From: Jessica Riches
Sent: 16 September 2022 14:49
To: Planning.Responses
Subject: FW: Ryefields - AL/31/22/PL
Attachments: 1324_DP302 - 03 Site Plan.pdf; 1324_DP305 - 03 Floor plan plot 2.pdf; 1324_DP307 - 02 Floor plan plot 3 and 4.pdf; 1324_DP311 - 03 Sustainability and biodiversity plan.pdf

From: Jessica Riches <Jessica.Riches@arun.gov.uk>
Sent: 12 September 2022 11:38
To: Kerry Simmons <Kerry@ss-p.co.uk>
Cc: Natalie McKellar <Natalie@ss-p.co.uk>
Subject: Ryefields - AL/31/22/PL
Importance: High

PLOT 3 (PLOT 4 SIMILAR/HANDED)
PROPOSED FIRST FLOOR PLAN
SCALE 1:100 @ a3

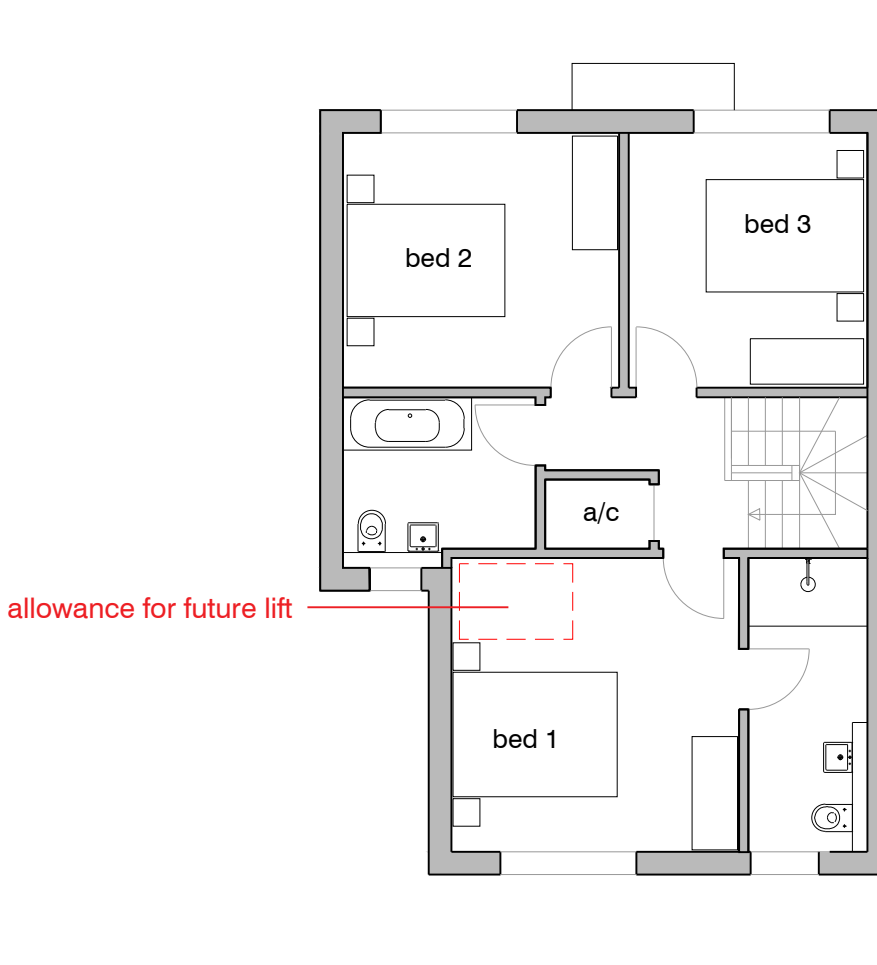
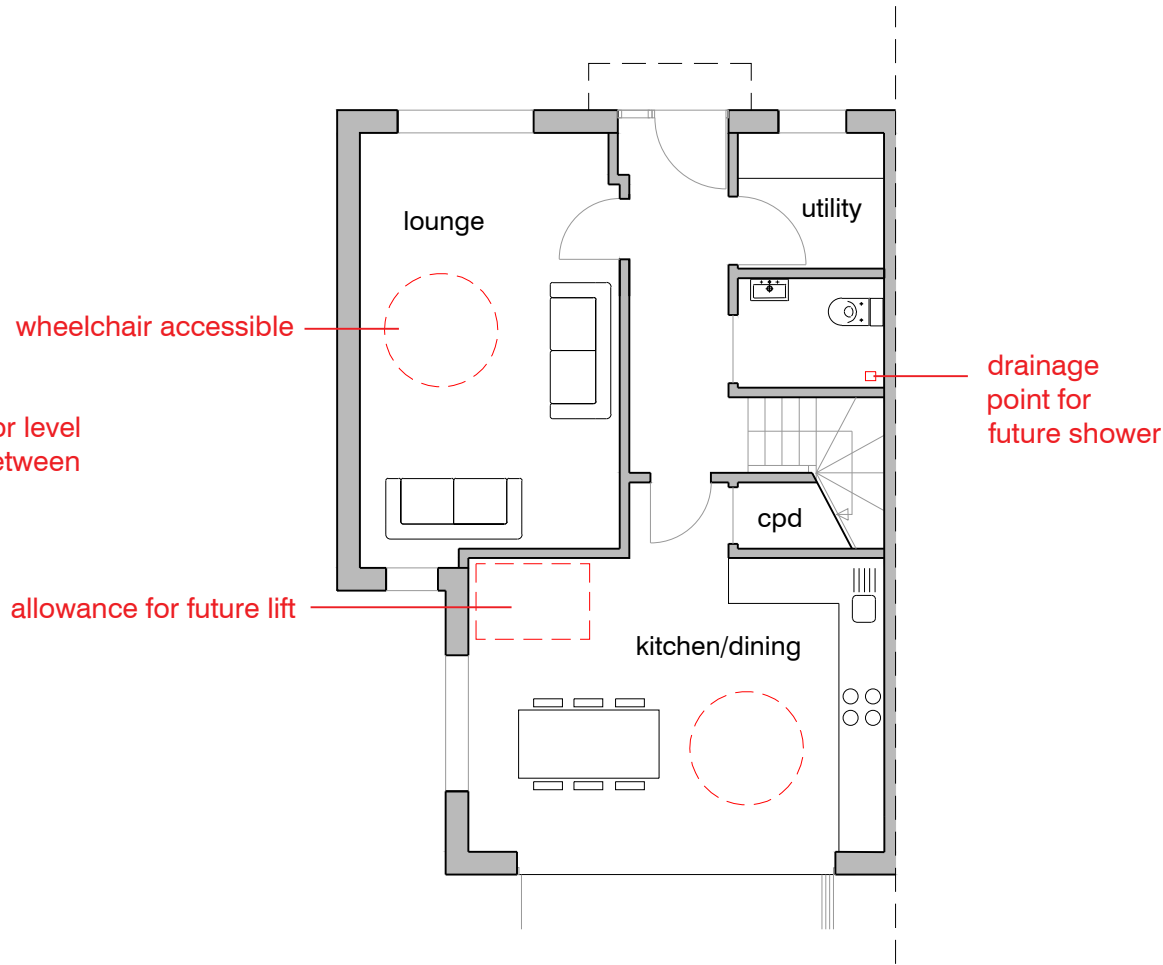
Another minor point which I think will be able to be resolved through a slight amendment to the plan, is that some bedrooms appear to be double bedrooms but don't meet the 11.5sqm minimum of the internal space standards set nationally. I believe Bedroom 3 of Plots 2, 3&4 are around 9sqm. Would you be able to amend this to a single bedroom for clarity?

The amended plans show revised and updated post and rail fencing to the site frontage as requested, and in addition bedroom 3 to plots 2,3,4 is now shown as a single bedroom in line with national internal space standards.

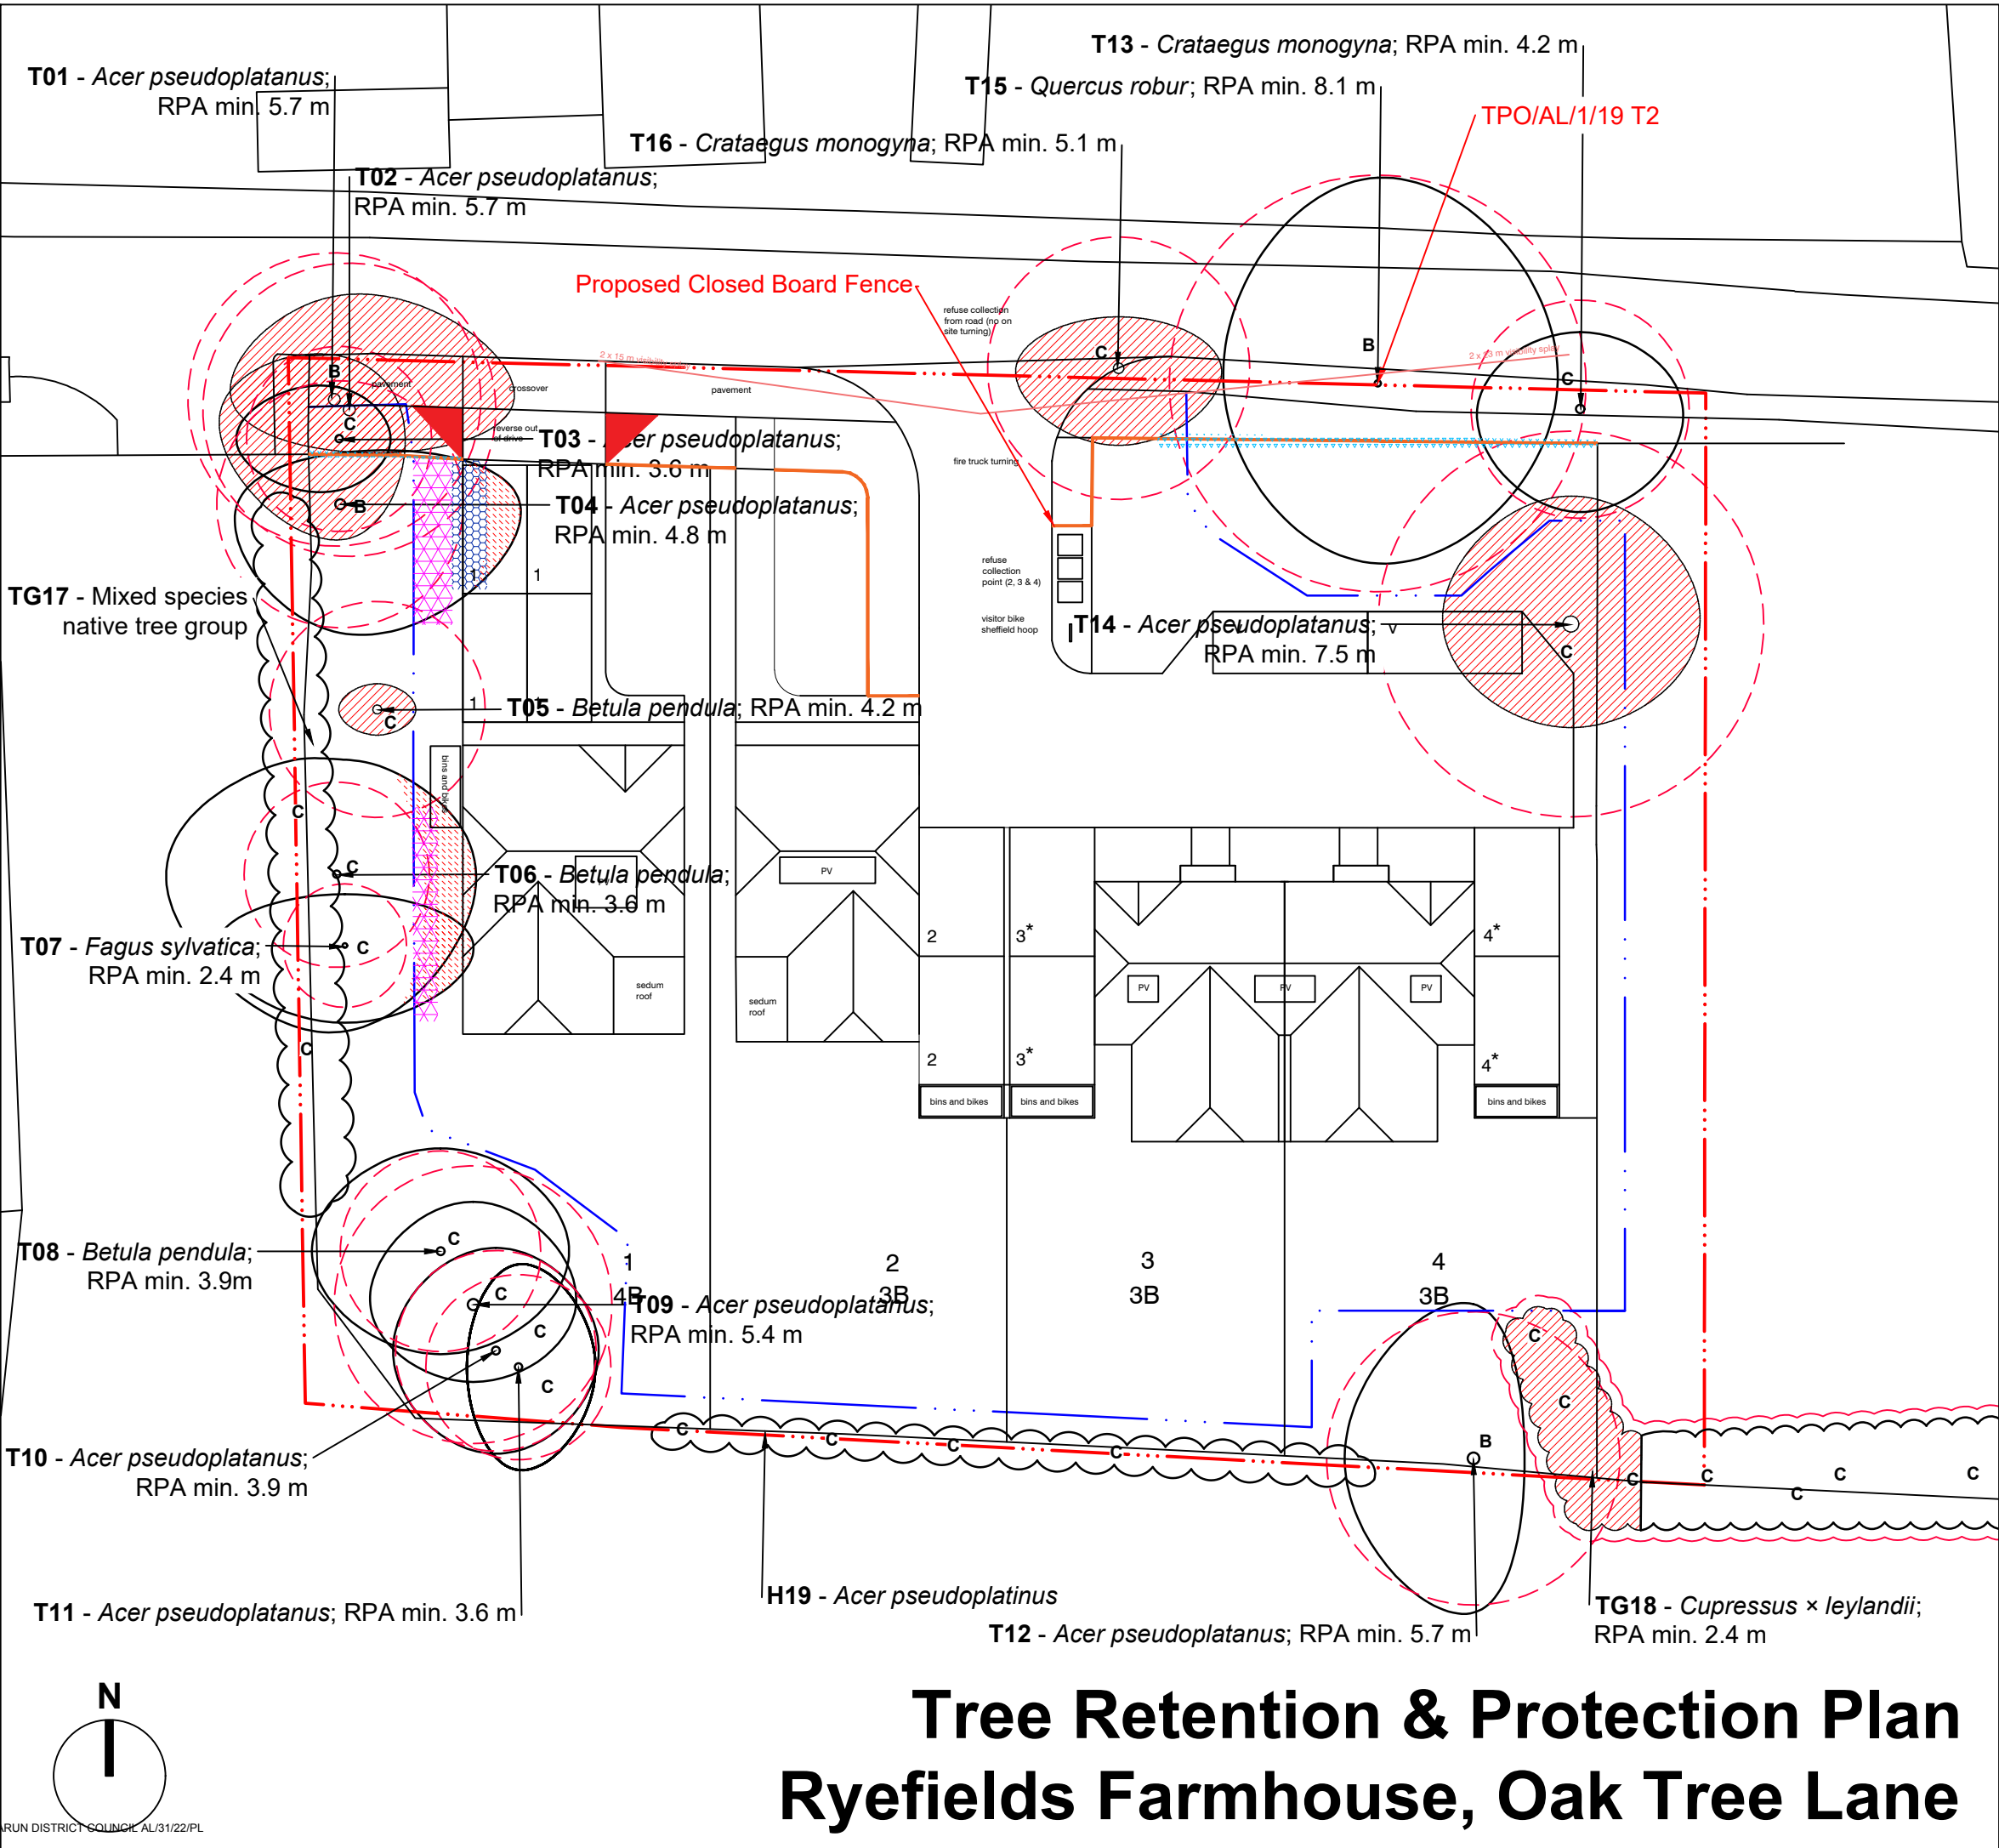
The close boarded fencing has implications for the RPA's and are visually different from the precedent of Oak Tree Lane. As this is included as an objection from the Tree Officer, and an objection from a design/appearance perspective, I wondered if you could amend or delete reference to close boarded fences forward of the front elevation out of the submitted plans? They are included within DP311 Rev 02, Tree Retention and Protection Plan, and Roof and Site Plan Rev 02.

Whilst I would be happy for some post and rail fencing in some areas long this frontage, I think this would be better to be set back away from the RPA of the TPO tree entirely, running adjacent to the visitor parking. In addition, the line of fencing running vertically to Plot 2 seems a bit redundant given the hedging and the layout.

1. I remain unsure if they are required to enhance construction of or widen the track. I assume not but it is too important to be left to chance. I recommend we seek clarification, as any such work within the root protection area (RPA) of T15 could be hugely damaging if not controlled by an approved arboricultural method statement (AMS).

I can confirm there is no intention for any widening of the track.
